# Drainage Report - Final\_V1\_Comments.pdf Markup Summary

in accordance with the requirements of volumes 1 and 2, and the El Paso County Drainage Criteria Manual. The Villas at Claremont development is located in the City of El Paso, Texas. The project is a residential development consisting of 100 units. The project is located on a 10-acre site. The project is located on a 10-acre site. The project is located on a 10-acre site.

SAND CREEK DRAINAGE BASIN PLANNING STUDY
 PRELIMINARY DESIGN PLANS

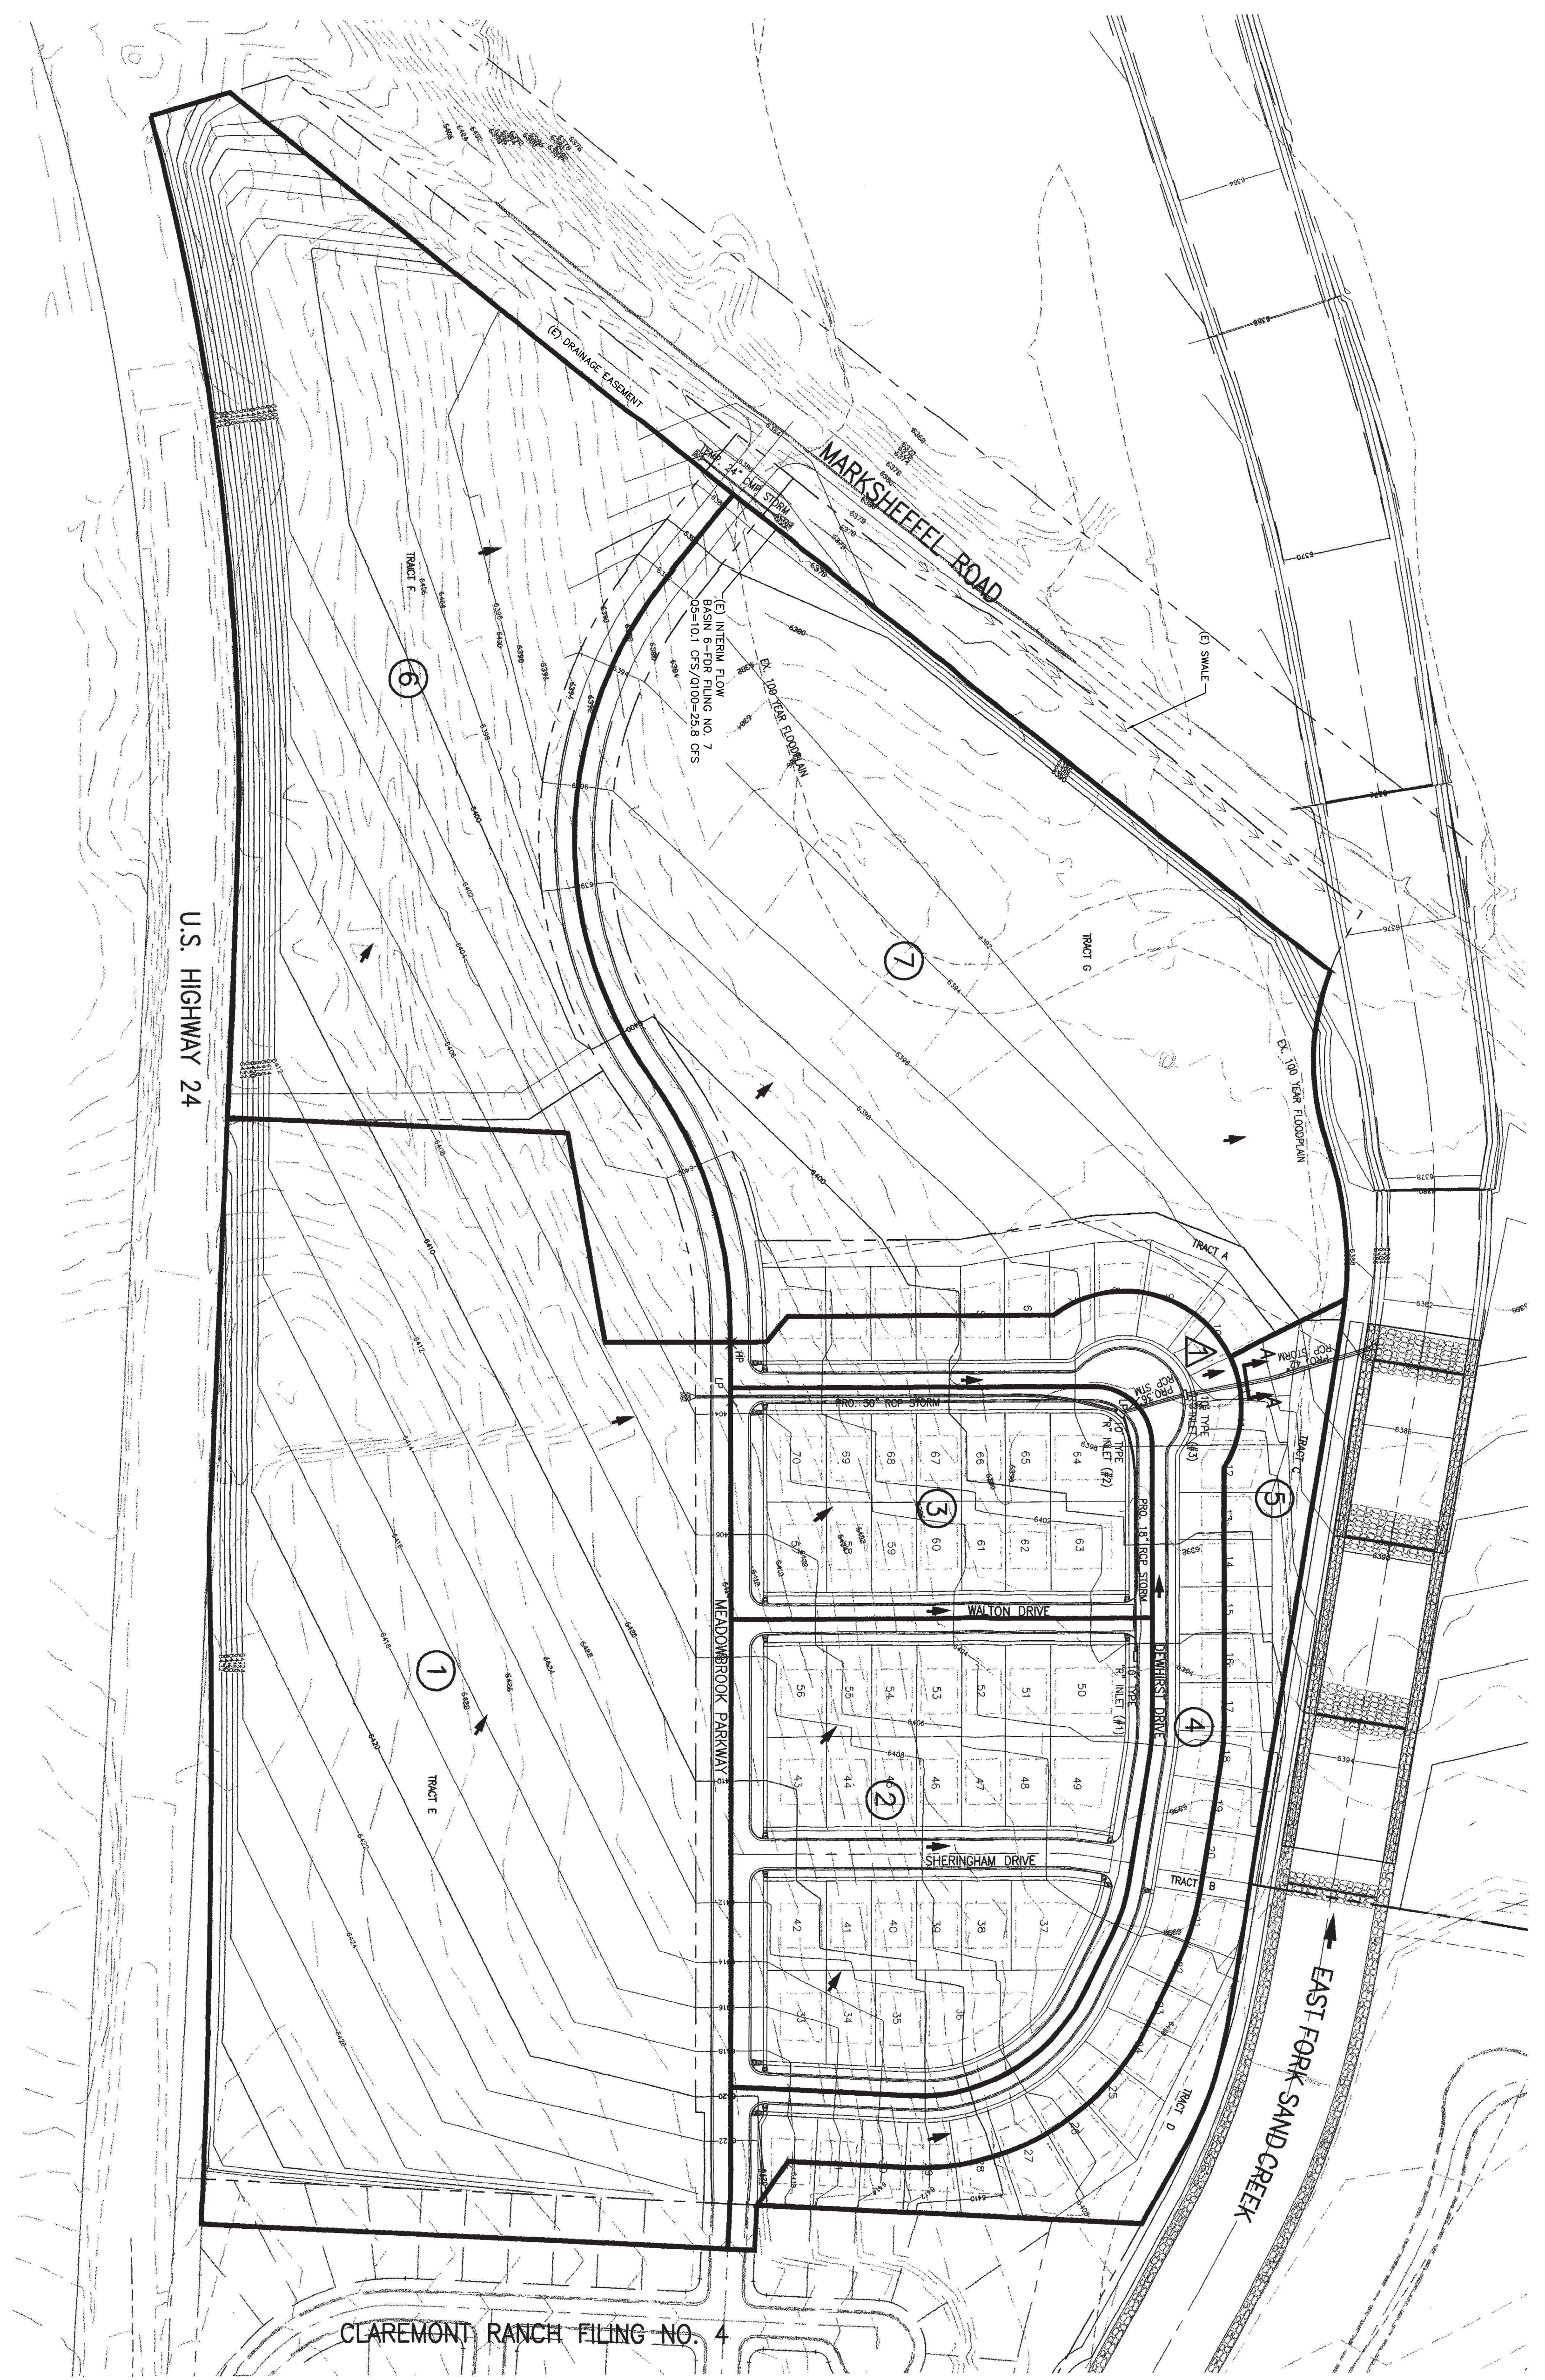
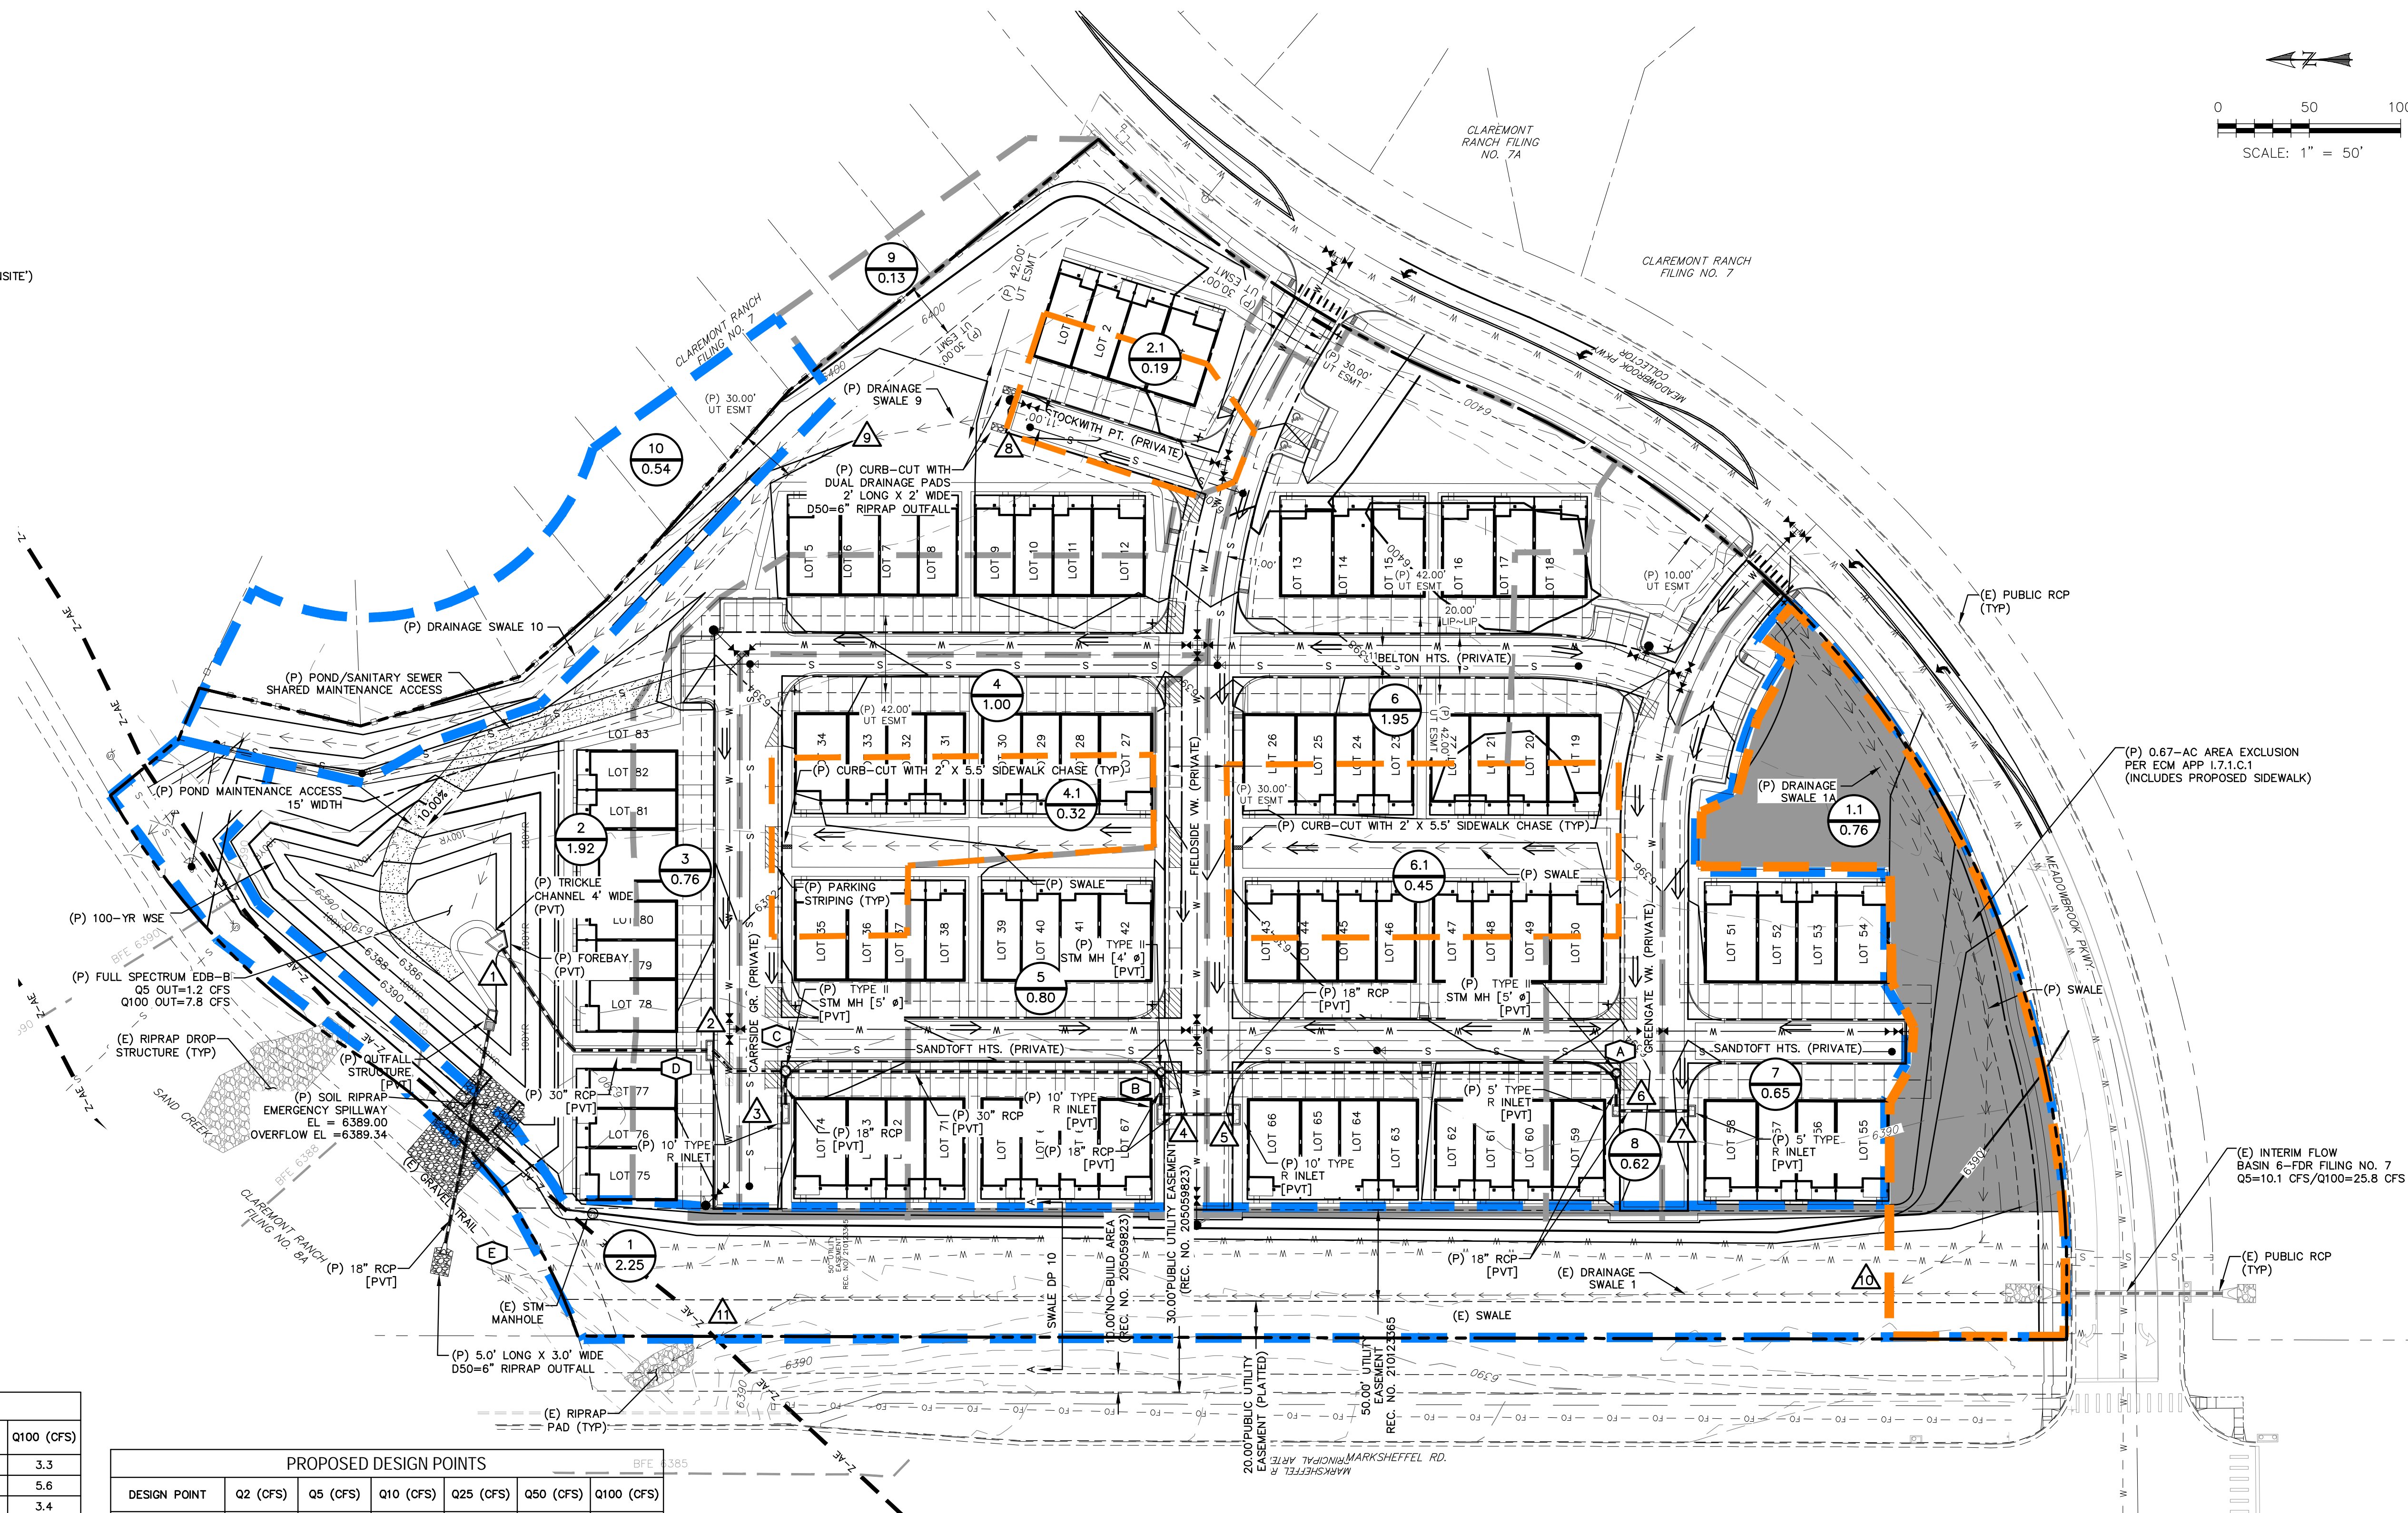
Include what flows are at culvert

Label existing swale

Flows shown do not match release rates shown on pond spreadsheet. Please update

Volumes do not match information shown on pond spreadsheet in appendix.

Create a design point for combined flows of Basin 1 and offsite flows from existing culvert. Provide analysis of existing swale and rundown that they are adequate to handle proposed flows.

Is this culvert still temporary or now permanent, and public/private? Please indicate and label what flows are.

This appears to be a ridge/HP through site. Hows does right portion of Basin 6 drain to the left? May need to break up into 2 separate basins.

What are these lines through median? Label or remove.

Label all internal roads as private

Label all easements

Label swale which is conveying flows from Basin 9.  
 Calculation needs to be included for swale design.

Label swale which is conveying flows from Basin 2.  
 Calculation needs to be included for swale design.

Label outlet protection and include design  
 calculations in appendix.

Provide BFE's in floodplain
